7 April 2026

TfNSW reference: REN25/00093/009

SSD-9619-Mod-1, Tilbuster Solar Farm Mod 1, 11915 New England Highway, Black Mountain; Response to Request for Further Information

TfNSW has reviewed the Memorandum titled "Re: 240071 – Tilbuster solar farm Modification SSD SSD-9619" prepared by NGH Consulting, dated 18 July 2025 as key documents for preparing this response.

Figure 2: Proposed Route Port of Newcastle to Site

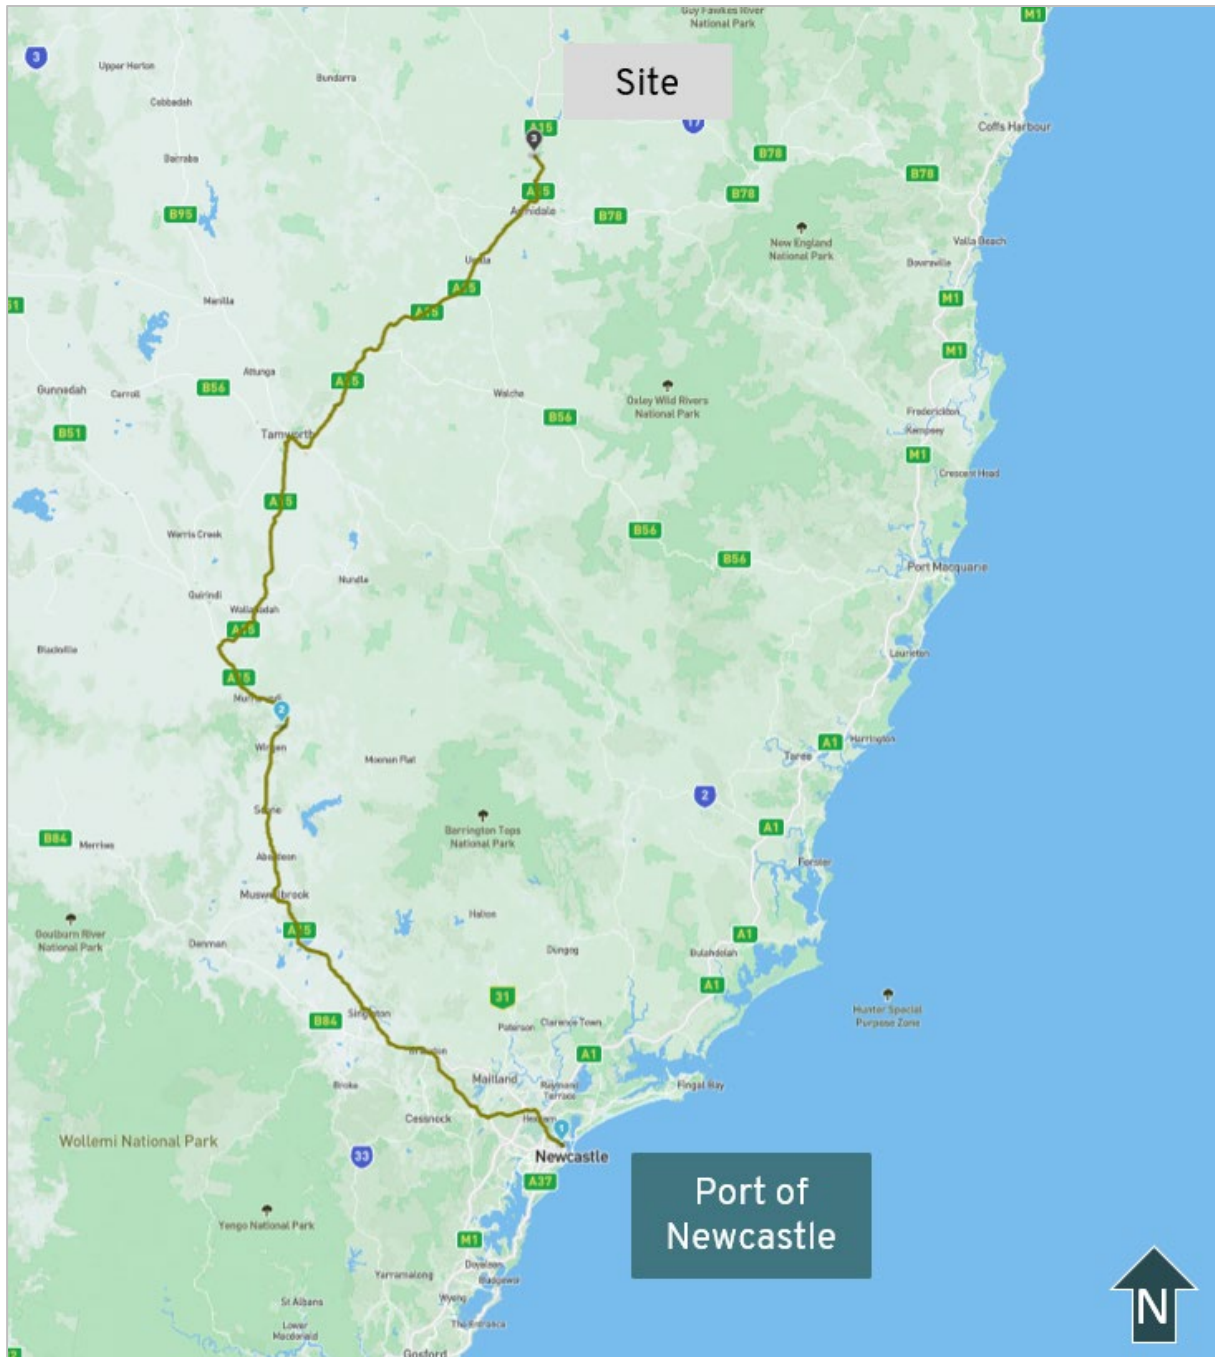
4.	TfNSW requires a concept level route assessment for the movement of the heavy vehicle requiring escort along the Port of Newcastle route. This route assessment is to include the swept path assessments mentioned in the Submissions Report, as well as the information requested in Attachment 2	Conditionally closed The applicant has provided swept paths for the additional part of the route within the Tilbuster 2 TIA. It is noted that the swept paths display the OSOM crossing on island medians at the Industrial Drive / George Street / Selwyn Street intersection. TfNSW recommends that the Applicant contact EnergyCo regarding the Port to REZ road upgrades conducted at this intersection and provide an updated swept path within the High-Risk OSOM TMP and/or project-specific TMP.

If the updated swept paths still show crossing of median islands, strategic designs for removal and/or strengthening must be provided to TfNSW for approval within the TMP(s). The TMP(s) must be provided to TfNSW for approval at least 4 months prior to any OSOM and project movements.
